July 11, 2018

**RE: Harnett County Land Use Existing Tank Application # 18-5-44308**

MILLENNIUM HOMES, LLC.  
THE TRAVIS WITH SCREEN PORCH  
LOT # 154 BALLARD WOODS  
SCALE: 1"=40'

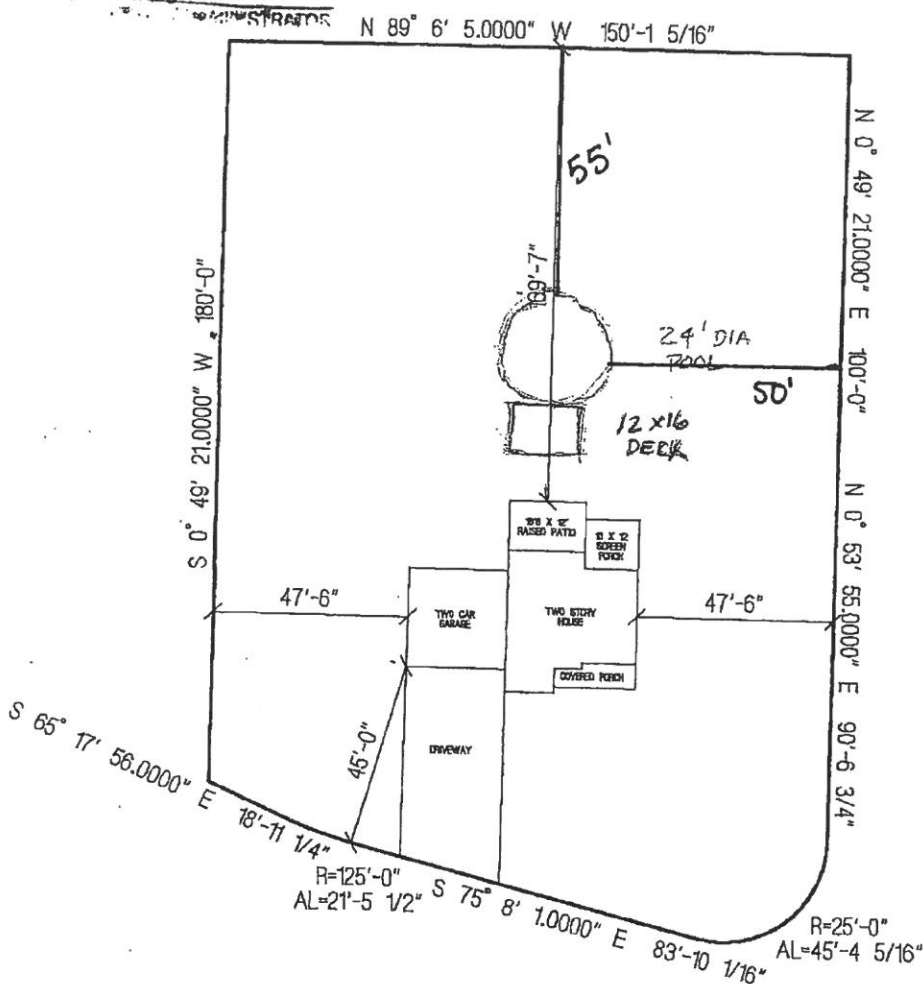
Based on the criteria set out in Title 15A, Subchapter 18A, of the North Carolina Administrative Code, Rules .1950, the evaluation indicated that the site is **UNSUITABLE** for. Therefore, your request for an existing tank is **DENIED**. The site is denied based on the following:

- 15A NCAC 18A.1950a {16} - Any swimming pool must be 15' from any part of septic system.**
- 15A NCAC 18.1945{b} - Each lot shall have original septic system plus repair area.**
- 15A NCAC 18A.1950 {10} - Any building to be 5' from septic tank and/or from drain line.**
- 15A NCAC 18A.1950{c} - Nitrification fields and repair areas shall not be located under paved areas or areas subject to vehicular traffic.**

POOL AS APPLIED ON TOP  
OF SUPPLY LINE  
[REVISE APPLICATIONS]
